Applicant: Mr John Preston

Proposal: First floor side extension to provide ancillary accommodation plus French doors to side elevation

Location
 PRO. PLAN 1:100@ A3 – REVISED

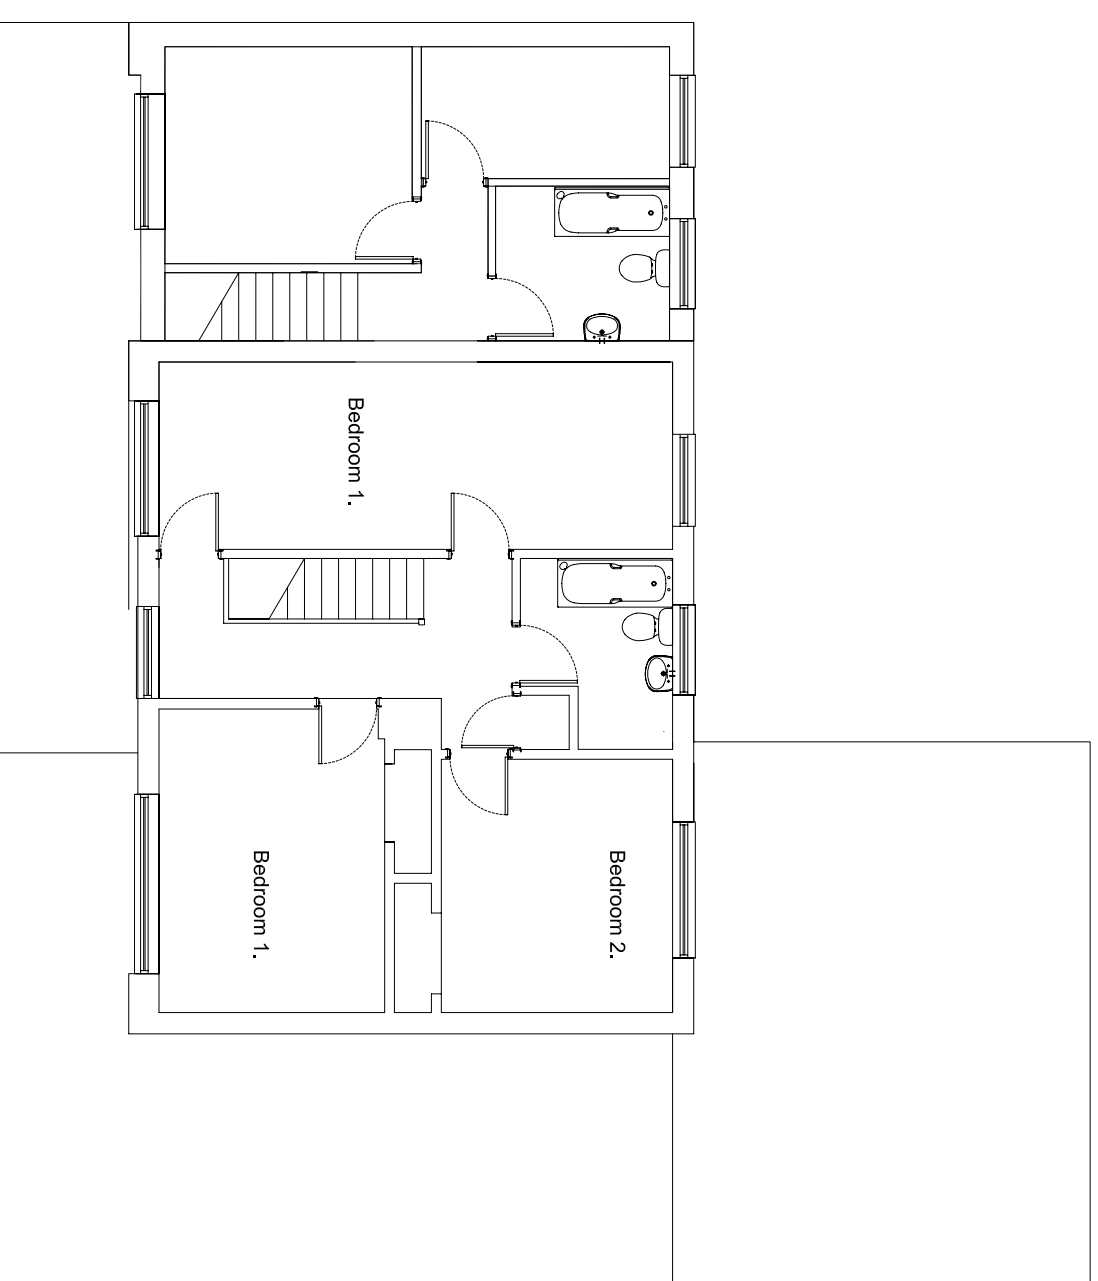
- 2.3. The proposals are for a two-storey side extension that would be 6.9m in height and 4.0m in depth from the existing side elevation of the dwelling. This would require that the existing garage in this location was removed. The design is at full height and depth (front to rear) as the existing dwelling with materials to match the existing.

- 2.4. A carport would be retained on the ground floor and extended beyond the present dimensions. On the first floor would be two rooms and a bathroom accessed by a new stairway and without direct access from the host dwelling.

- 8.11. To the east of the site No.5 St Giles Close backs onto the site of the proposed extension. There is currently a gap of 15m between the rear of No.5 and the first floor of the original dwelling at No.13. The depth of the garden of No.5 is 10m and so a 4.0m extension to the side of No.13 would come to roughly 11m from the rear of the dwelling.

Location  
 PRO. ELEVATIONS 1:100@ A3 – REVISED

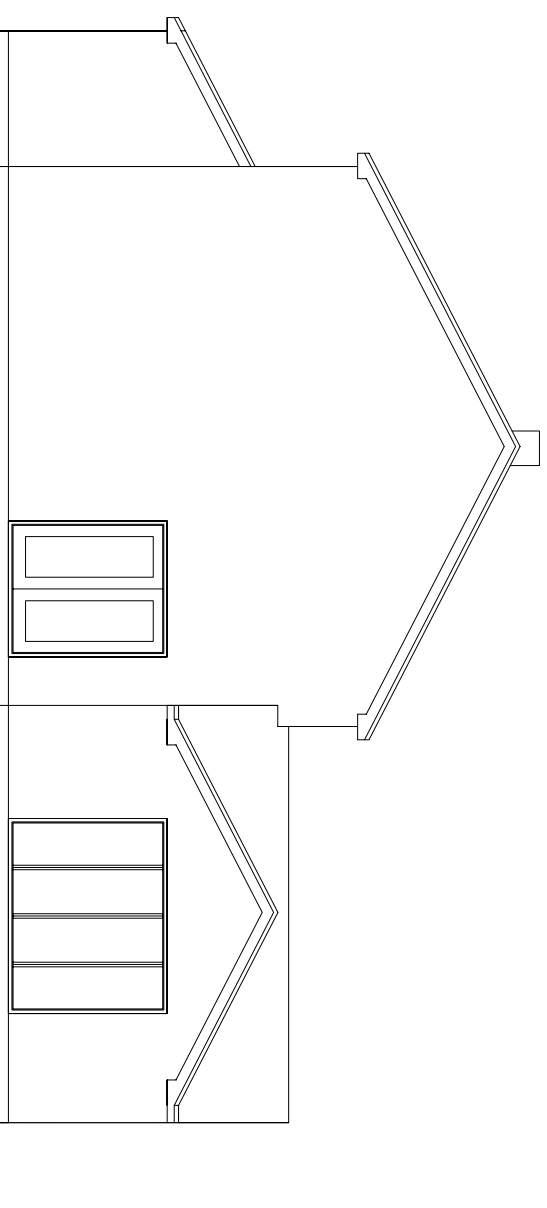
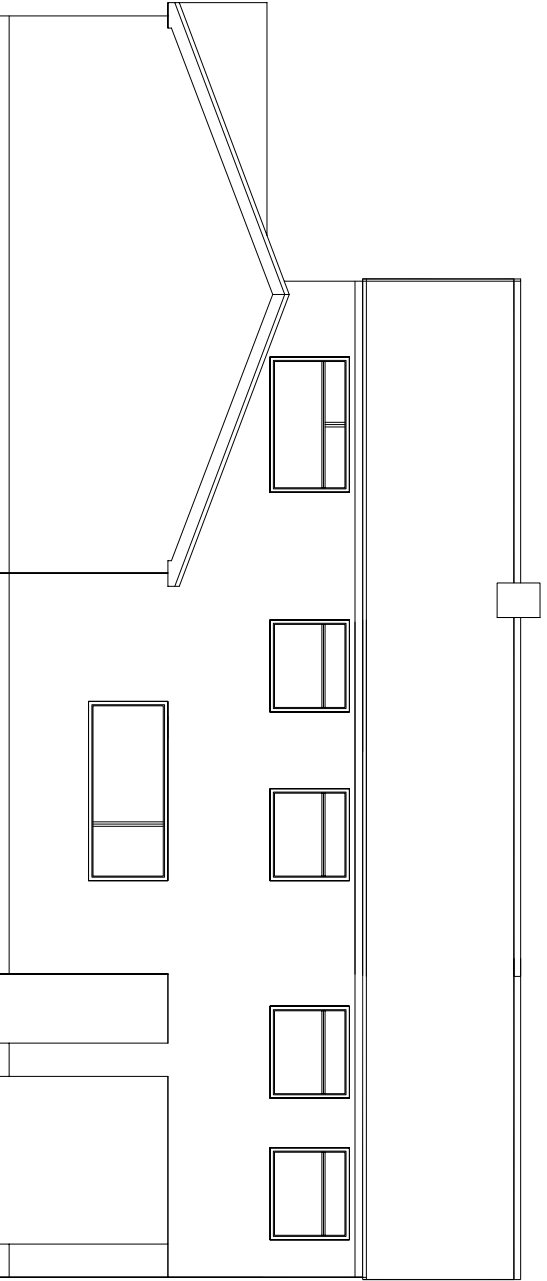
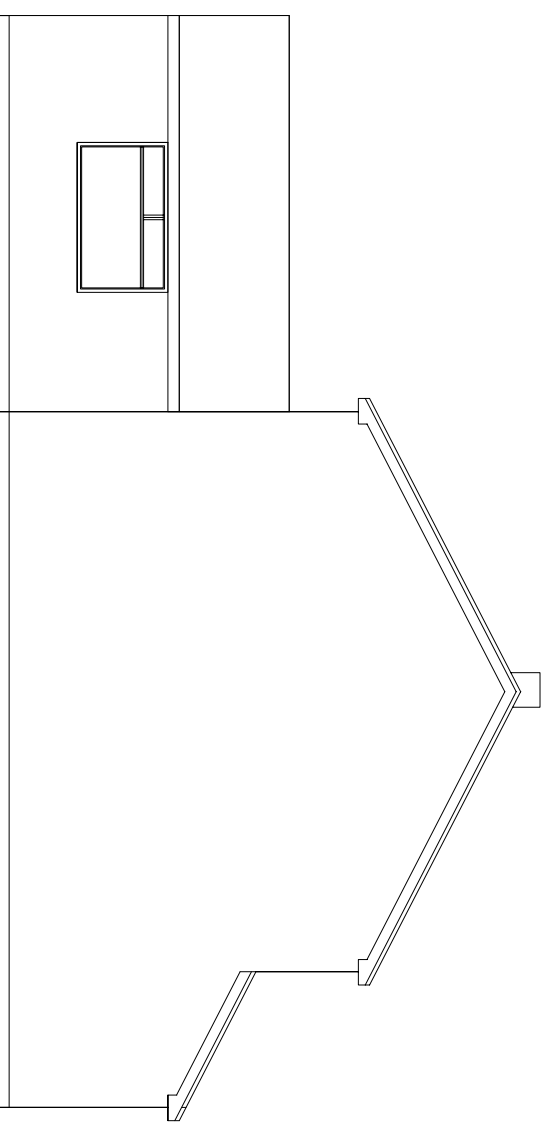
8.5. The proposals are for a full height and depth extension to the side at two stories. Whilst this would be slightly less than half the width of the original dwelling the lack of subservience in the design would result in a very large principal elevation facing the street. The dwellings in the rest of the street scene and built at the same time are relatively modest in scale where they face the street – with two designs predominating – either gable onto the street or perpendicular to it. The overly large proposals before me would result in a design which would dominate both the original host dwelling and would sit uncomfortably in the street scene.

8.6. The dwelling has already been extended in the past to the rear and side. This is apparent if not prominent in the street scene. It adds to the bulk of the building in its present form and would serve to reinforce the overtly large nature of the proposed extension.

- 8.12. The design guide 2007 recommends a minimum gap of 14m in such relationships – between a windowless elevation and a neighbouring habitable room. Added to the perceived massing that would be apparent from such a relationship the fact that it is to the west of the modest garden space enjoyed by the residents of No.5 such an enlargement would block a significant proportion of afternoon and early evening sunlight reaching much of the garden.

- 8.14. With a two-storey windowless elevation 11m from the rear elevation of No.5 and to the west of the garden space; the harm to the amenity of the residents would be considerable and therefore I consider that the proposal fails to accord with Government guidance contained with the NPPF and saved Policy C30 of the Cherwell Local Plan 1996 and Policy ESD15 of the CLP 2011-2031 Part 1 that seek standards of amenity and privacy acceptable to the Local Planning Authority.

1. The proposed development, by virtue of its design would result in an overly large and incongruous form of development, lacking subservience that would fail to sympathetically integrate into the surrounding built environment or to respect the scale of the host dwelling. The proposal would thus be contrary Policy ESD15 of the Cherwell Local Plan 2011-2031 Part 1, saved Policies C28 and C30 of the Cherwell Local Plan 1996, and Government guidance contained within the National Planning Policy Framework.

2. The proposed development, by virtue of its form, scale, massing and siting, would fail to safeguard the living conditions neighbouring residents and result in an imposing and overbearing form of development in respect the residents of No.5 St Giles Close. The proposed development would result in a significant loss of outlook to these neighbouring residents. The scheme is therefore contrary to Policy ESD15 of the Cherwell Local Plan 2011-2031 Part 1, saved Policy C30 of the Cherwell Local Plan 1996 and Government guidance contained within the National Planning Policy Framework.
